Consultation Response from KC, Conservation and Design
2020/92307 Penistone Road/, Rowley Lane, Fenay Bridge, Huddersfield, HD8 0JS
Outline application for erection of residential development
Date Responded: 14/12/20
Responding Officer: Craig McHugh
Responding Ref: KB5/142
Summary

Figure 7: Viewshed from Viewpoint 1 to north-east of Woodsome Hall

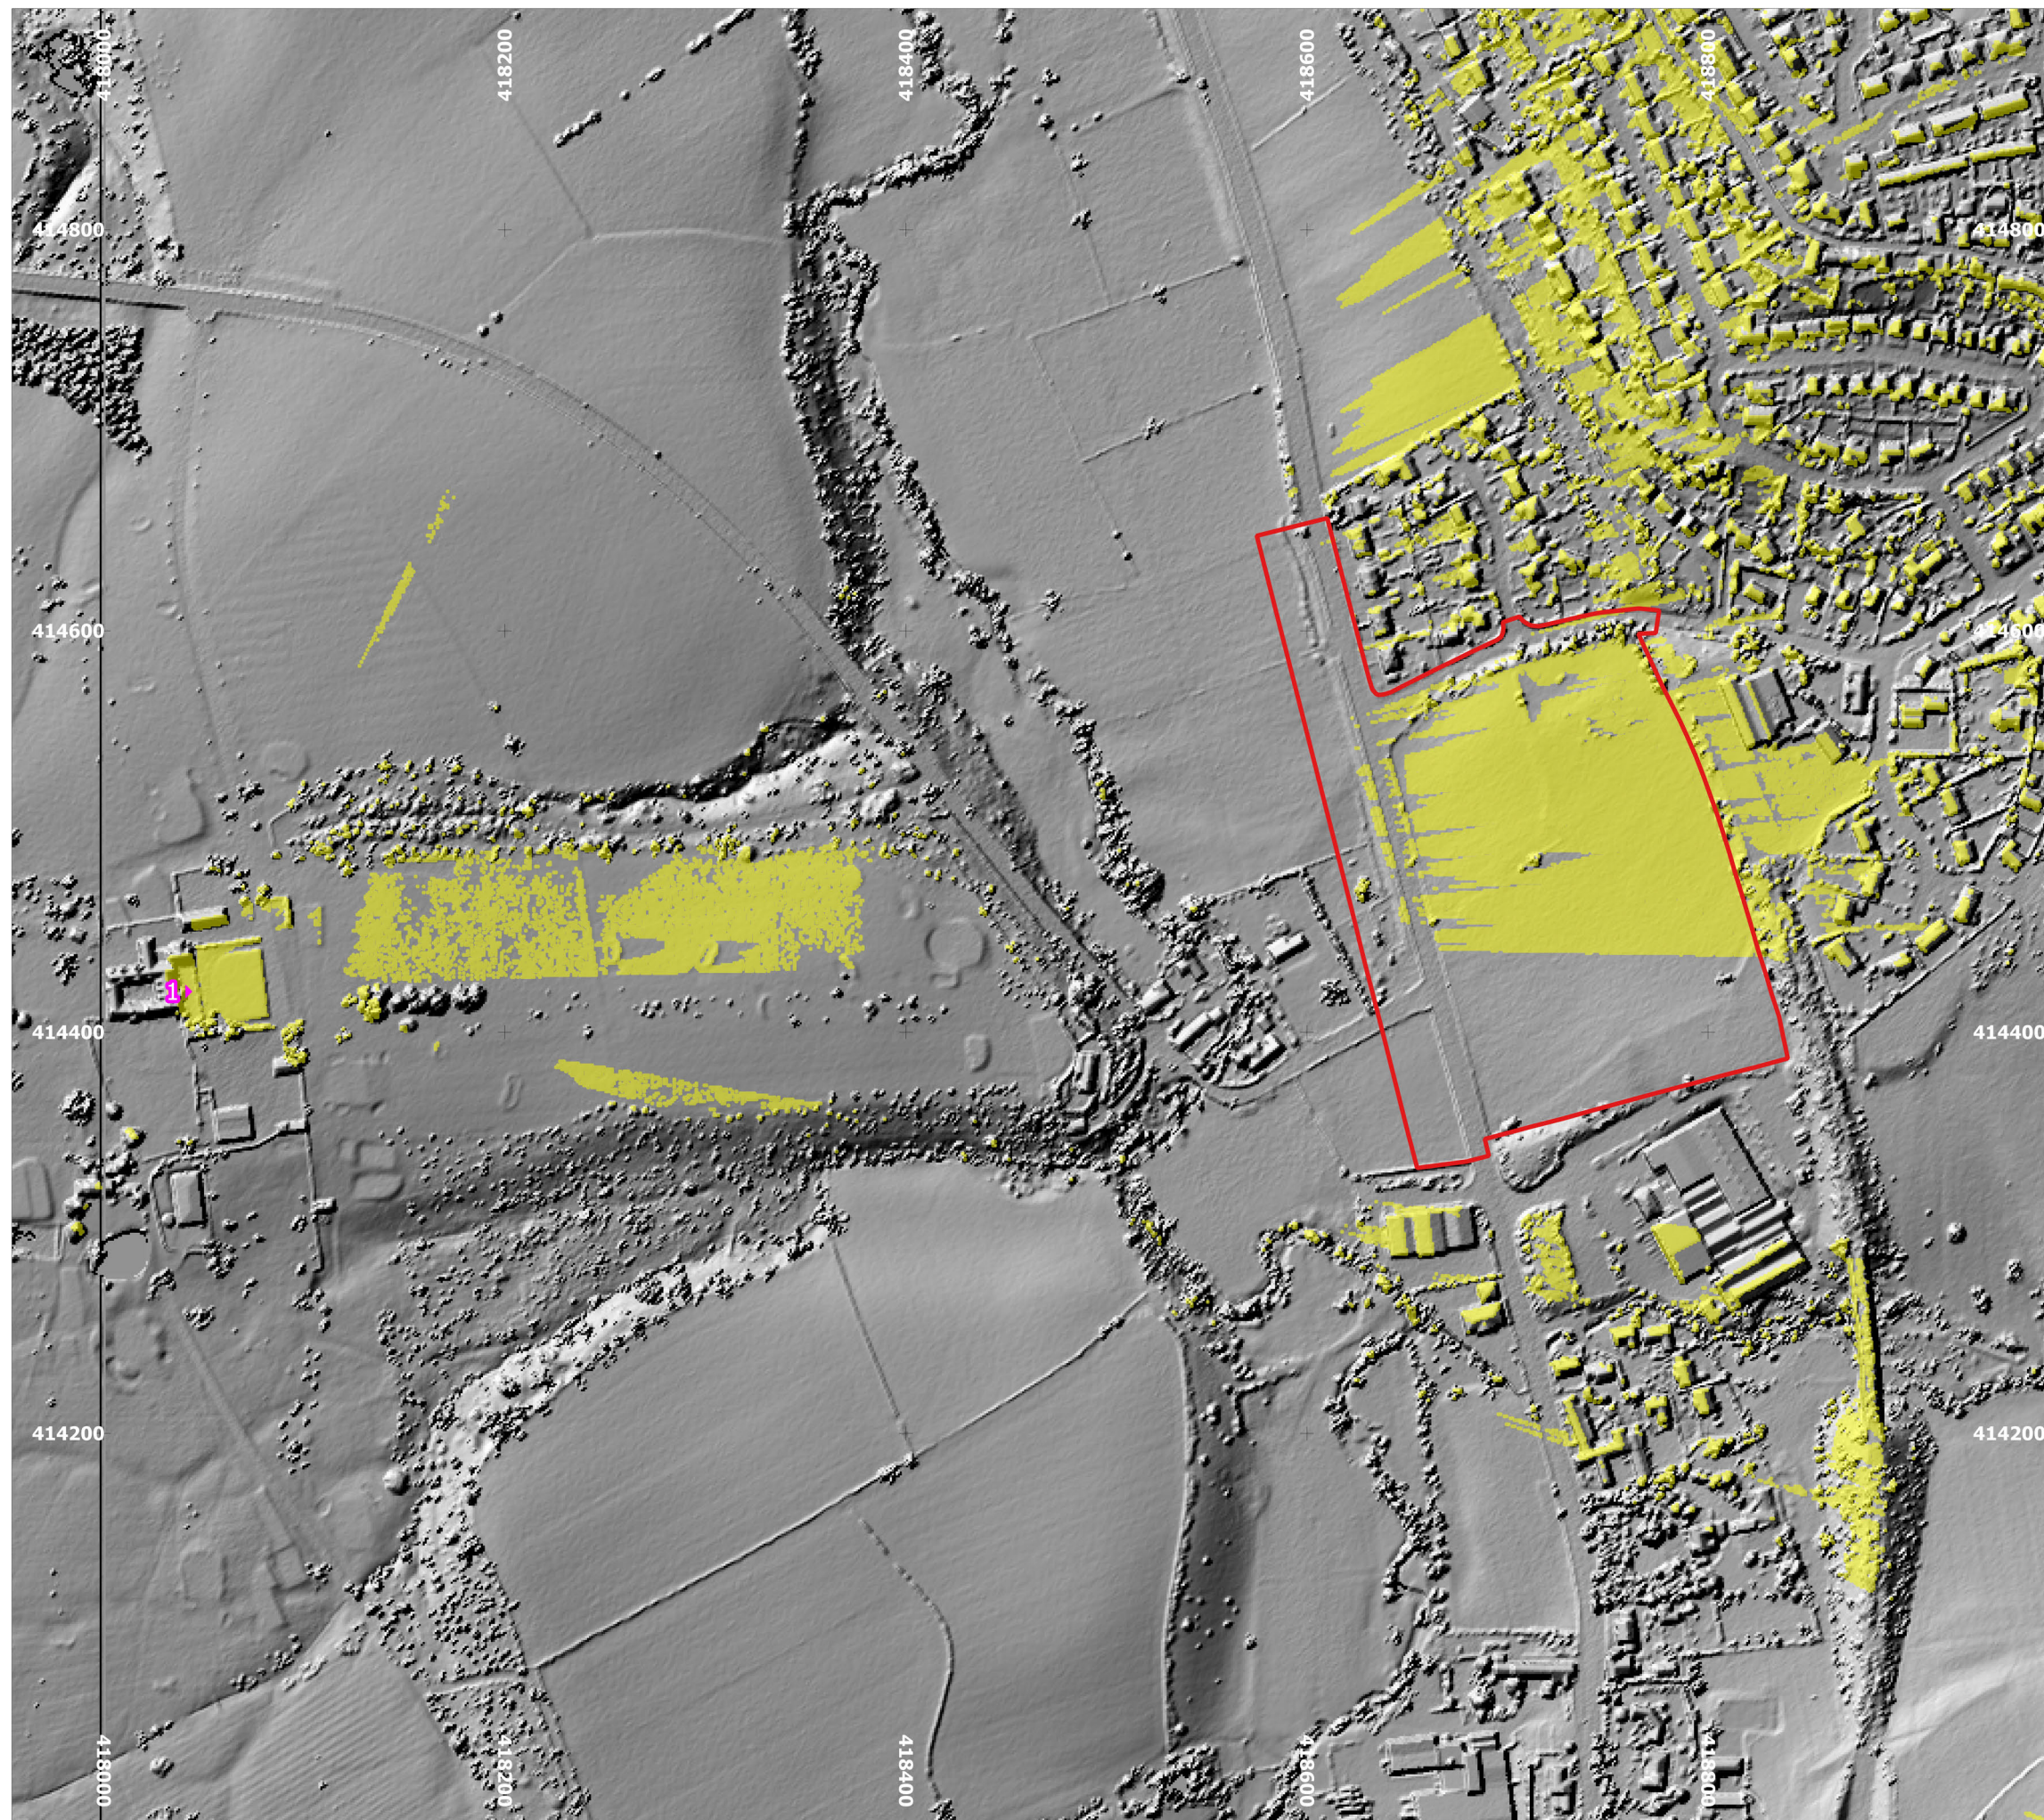
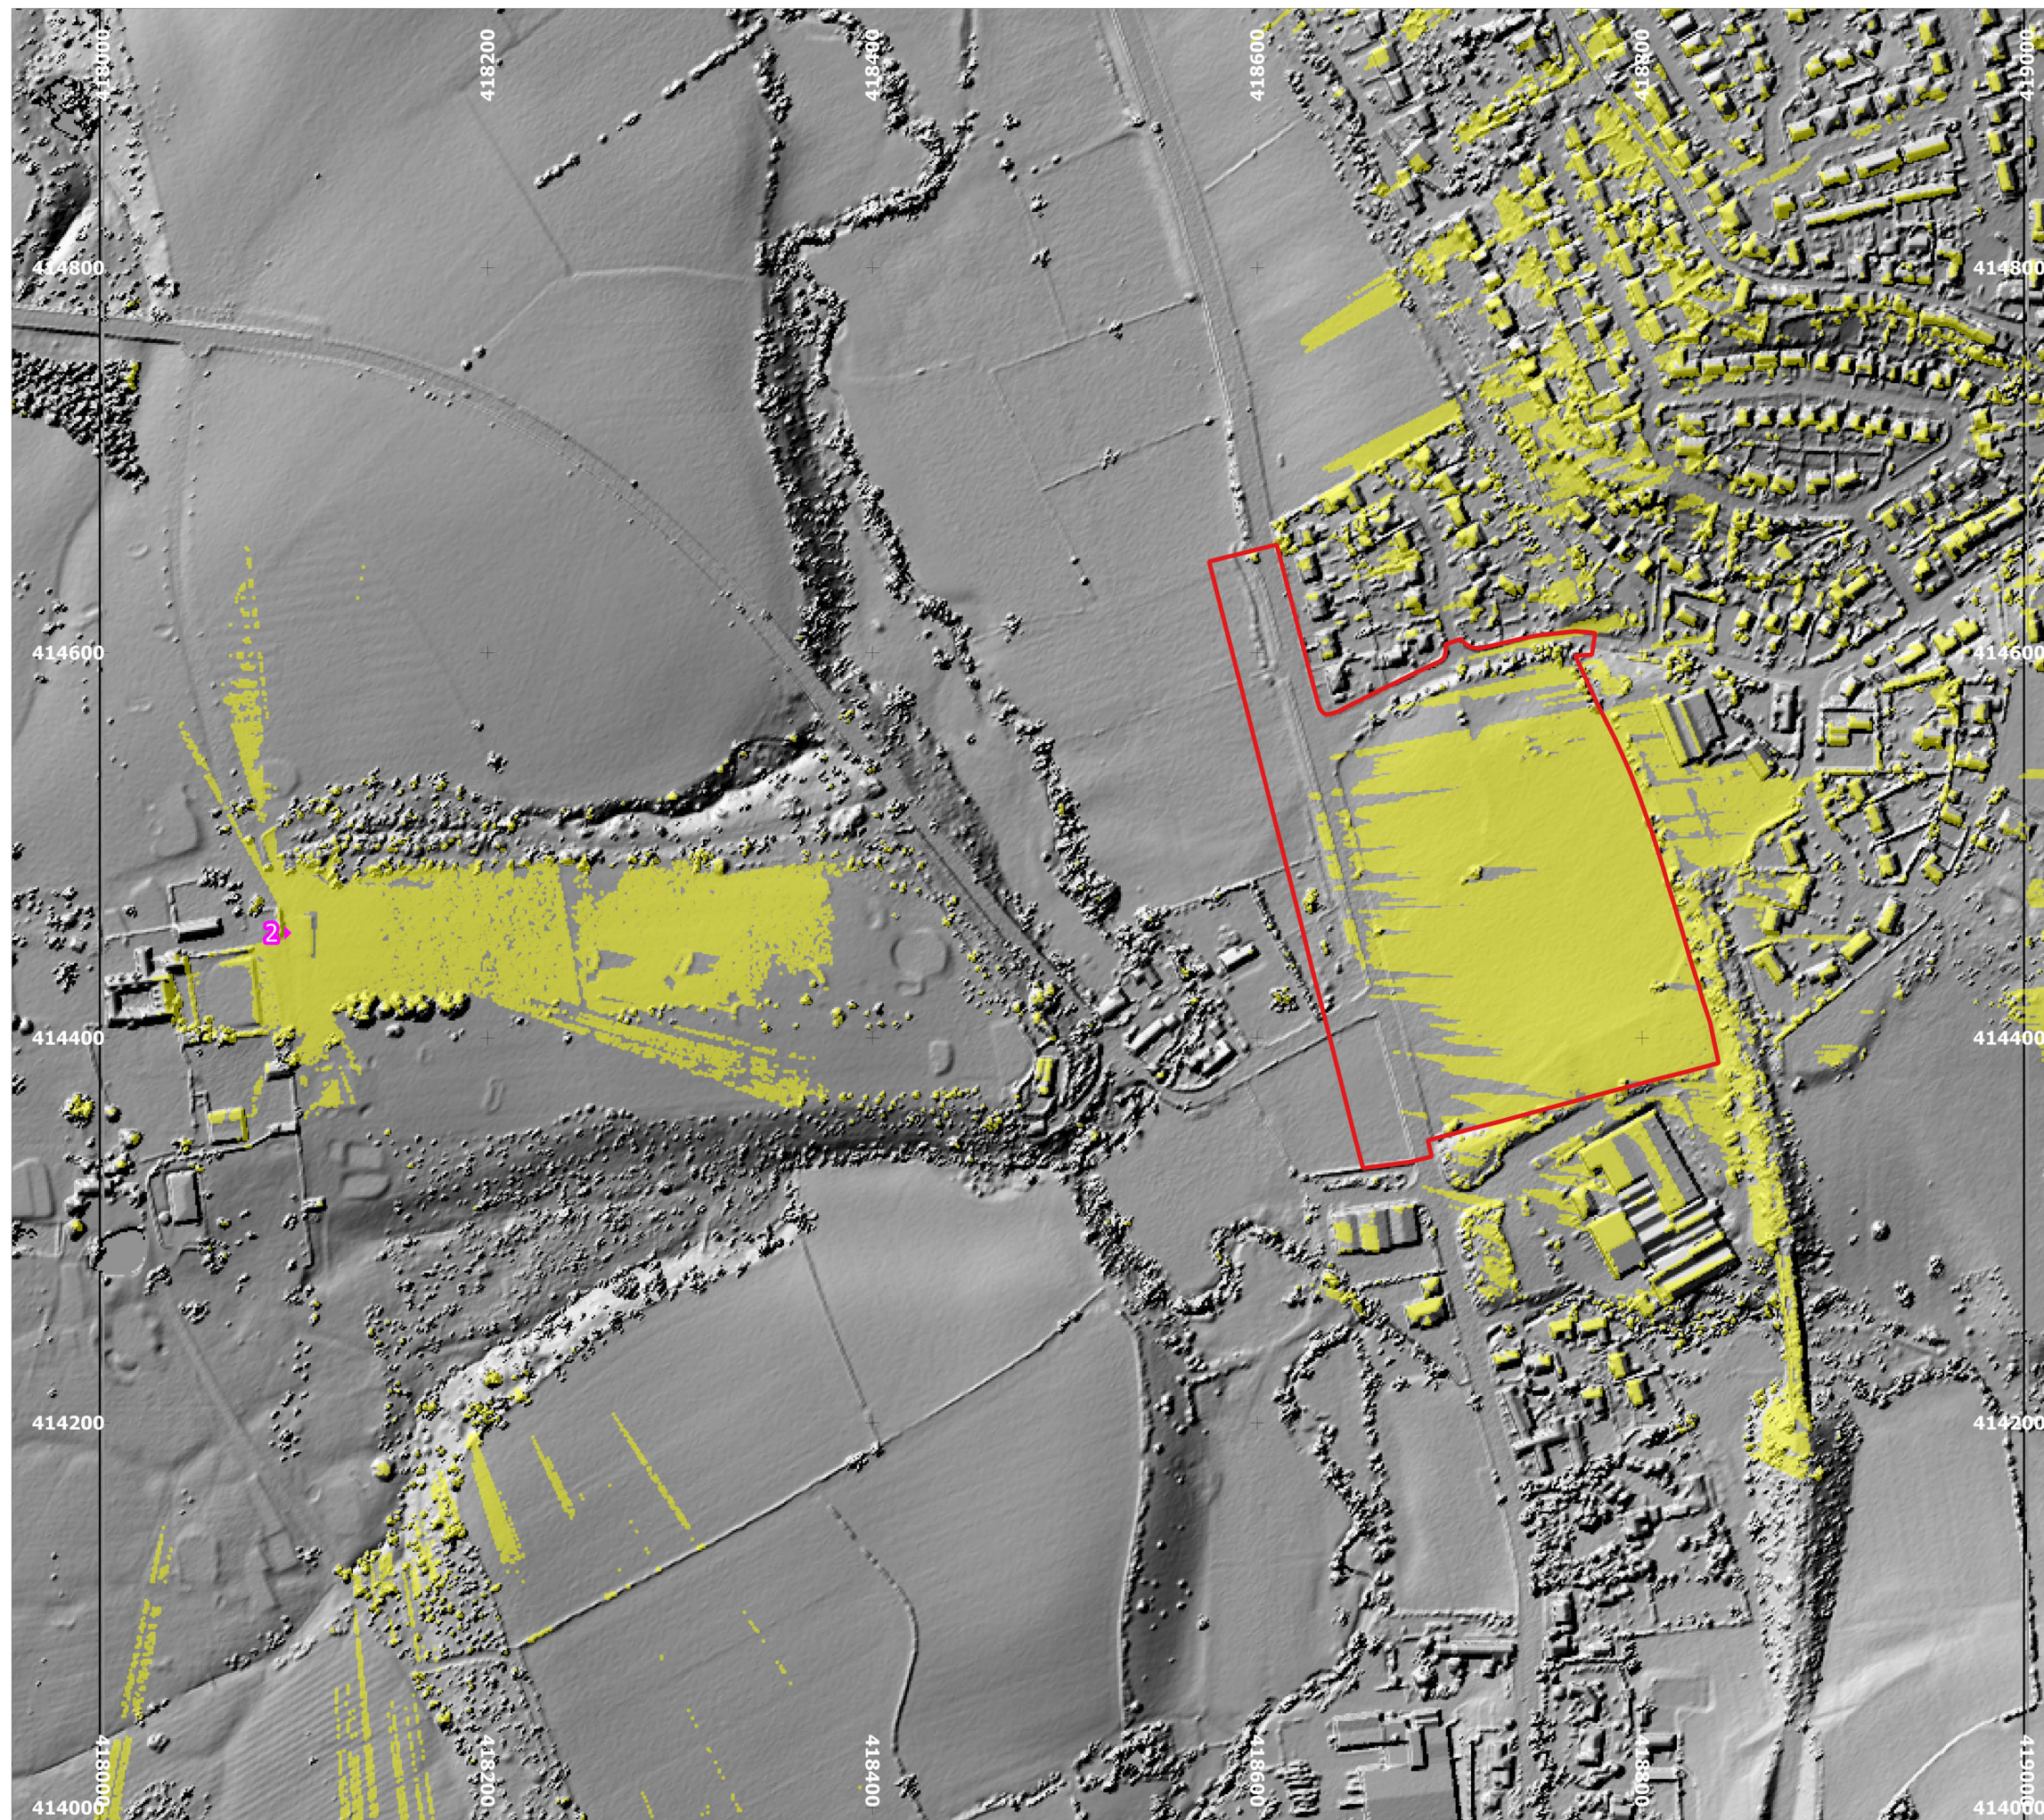
The application is accompanied by a heritage statement. This includes viewsheds and photographs from three viewpoints. These viewpoints are suitable for illustrating the impact of the development on setting of Woodsome Hall, specifically its terrace, lawn and parkland and surviving rural setting. They do not however include a visual impact assessment to adequately illustrate that impact, nor are they sufficient to evaluate the impact of the currently proposed road junction or the proposed housing development. Similarly, the Design & Access Statement appears to be rather ambiguous in terms of the extent of the proposed road networks and the integration of the main vehicular routes. Consequently, it is not possible to evaluate the impact on the character of the landscape or the designated heritage assets, or plan for adequate mitigation.
